RE: QUANZ CAR CARE FACILITY (C-12/D5A)
(9101 Eagle Ranch Rd NW)
ENGINEERS CERTIFICATION FOR CERTIFICATE OF OCCUPANCY
ENGINEERS STAMP DATED 8/8/2001
ENGINEERS CERTIFICATION DATED 7/5/2002 Rev. 8/1/2002

**RE: QUANZ CAR CARE (C12-D5A). GRADING AND DRAINAGE PLAN FOR
FOUNDATION PERMIT, BUILDING PERMIT AND SO#19 PERMIT
APPROVALS. ENGINEER'S STAMP DATED AUGUST 8, 2001.**

#### A PROPOSED GRADING AND DRAINAGE PLAN

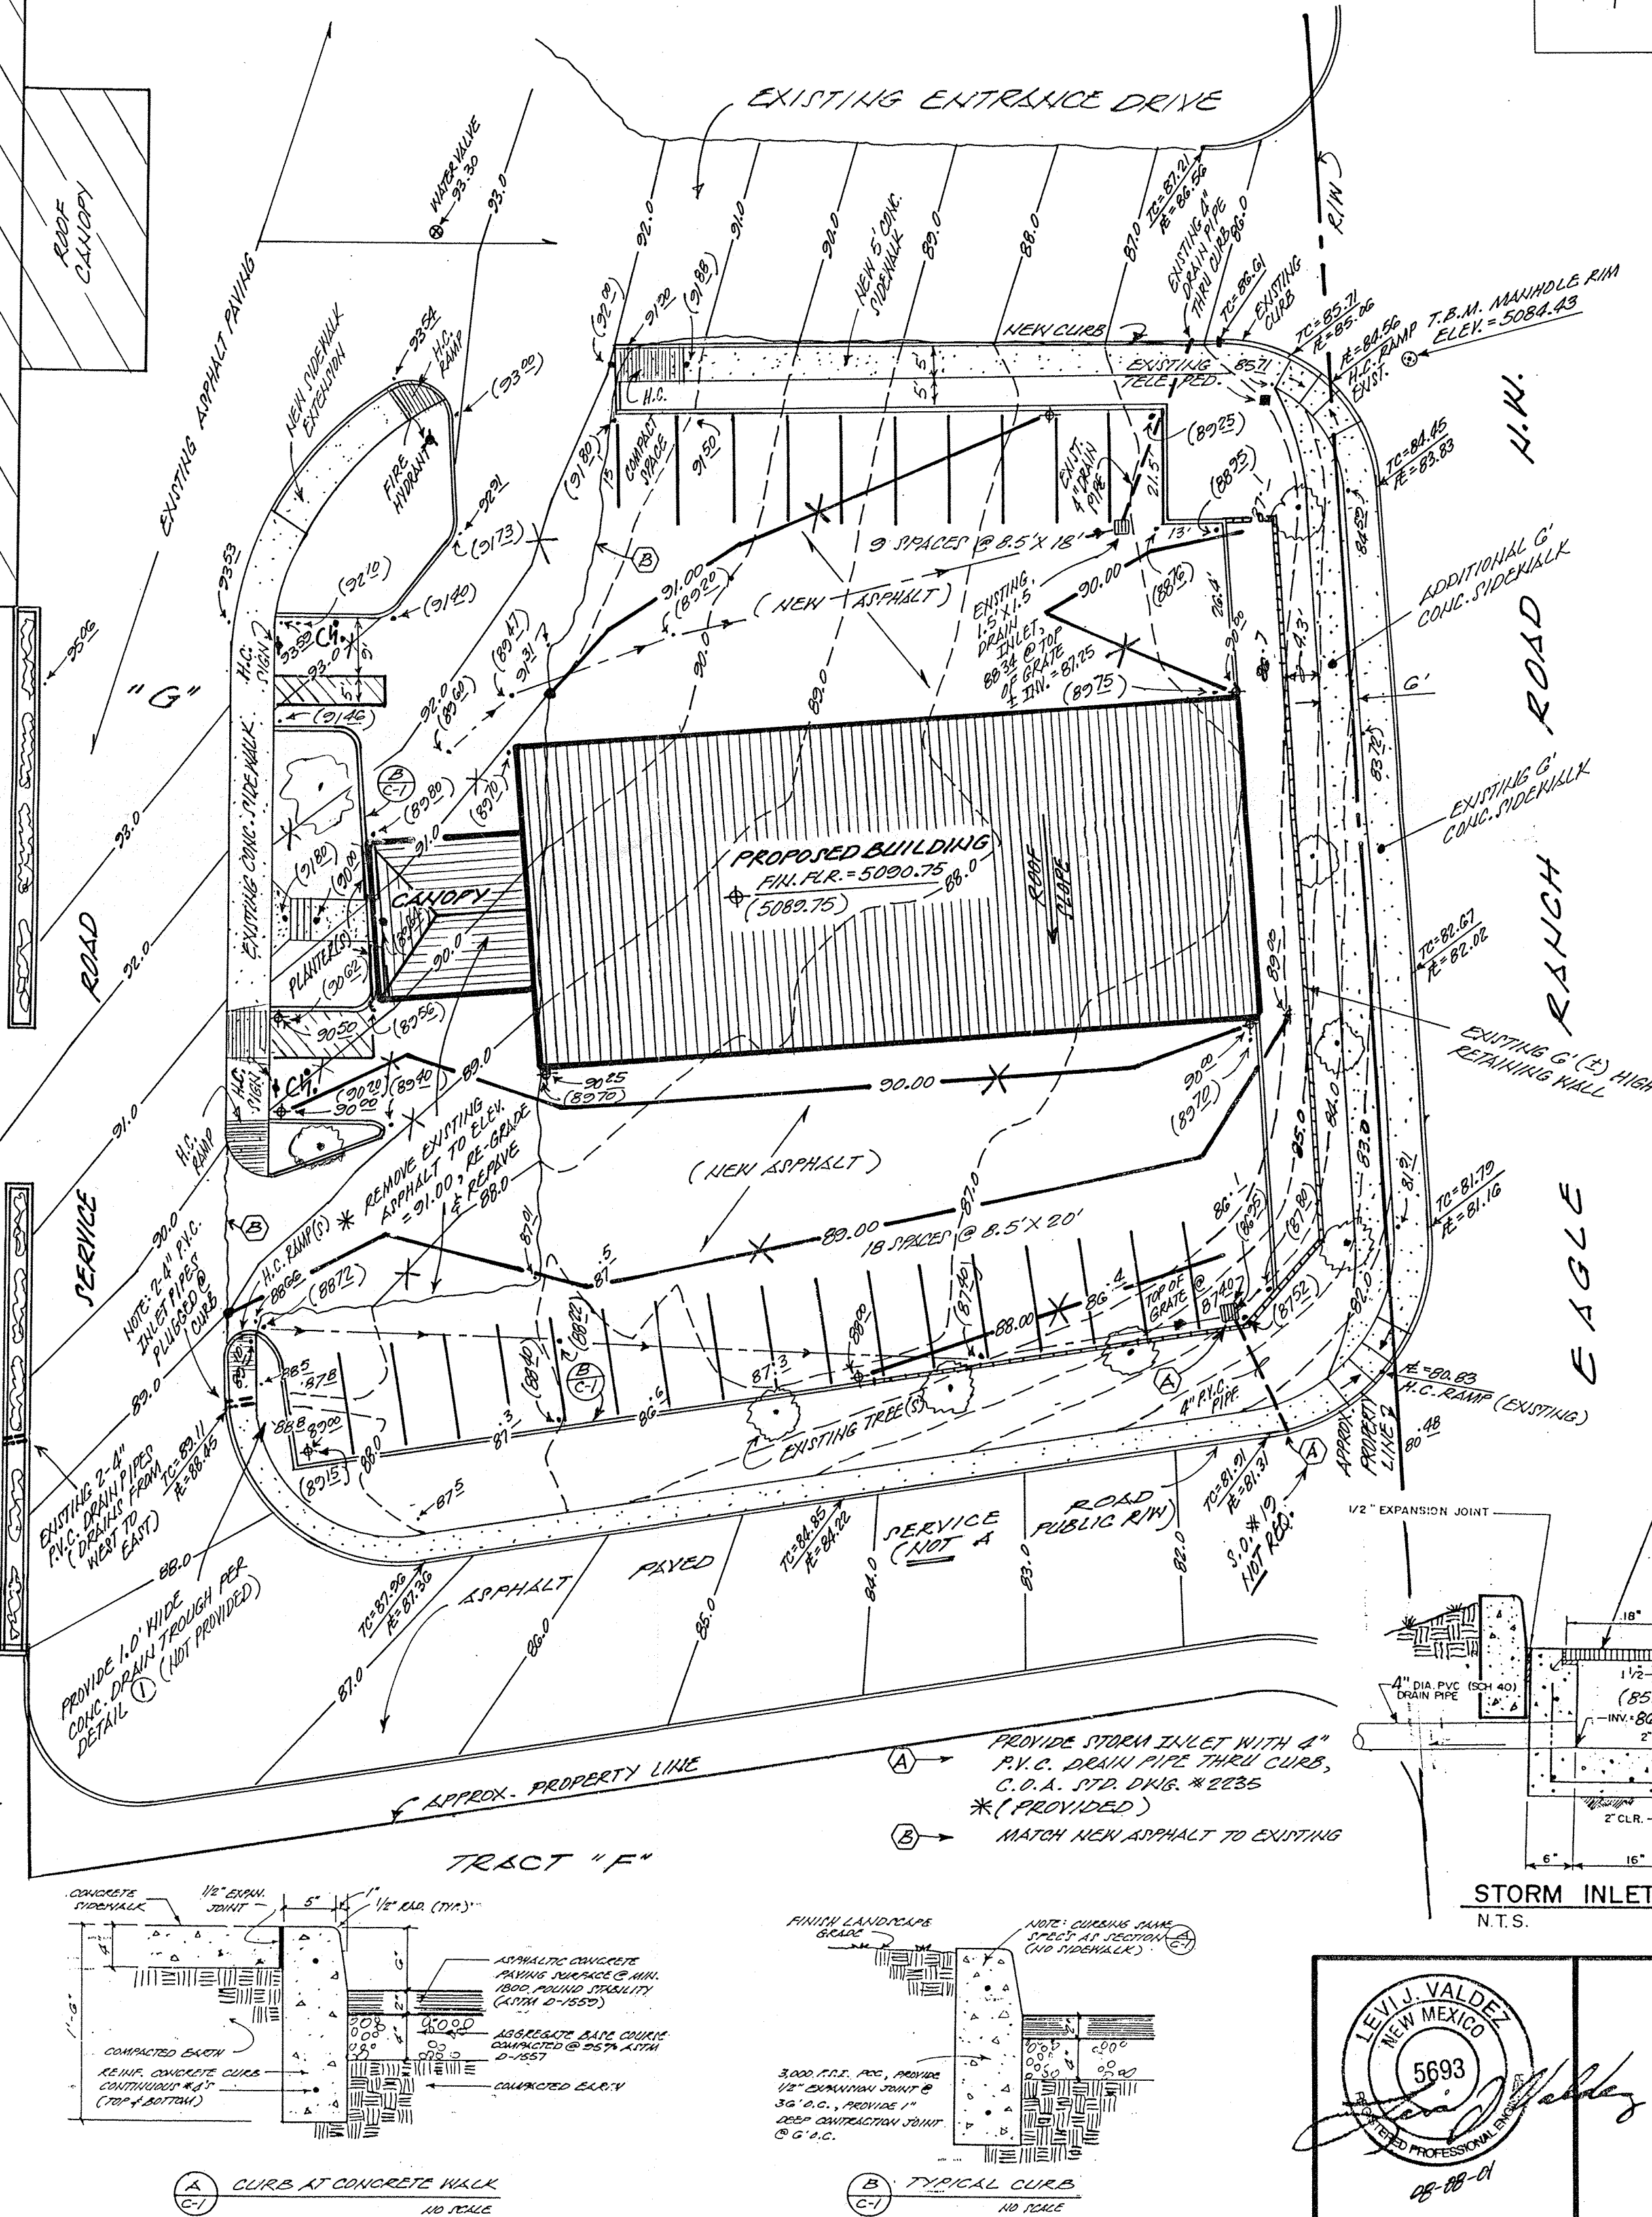
*** Remove the word "Proposed" from the Title Block. This is the approved G & D Plan.
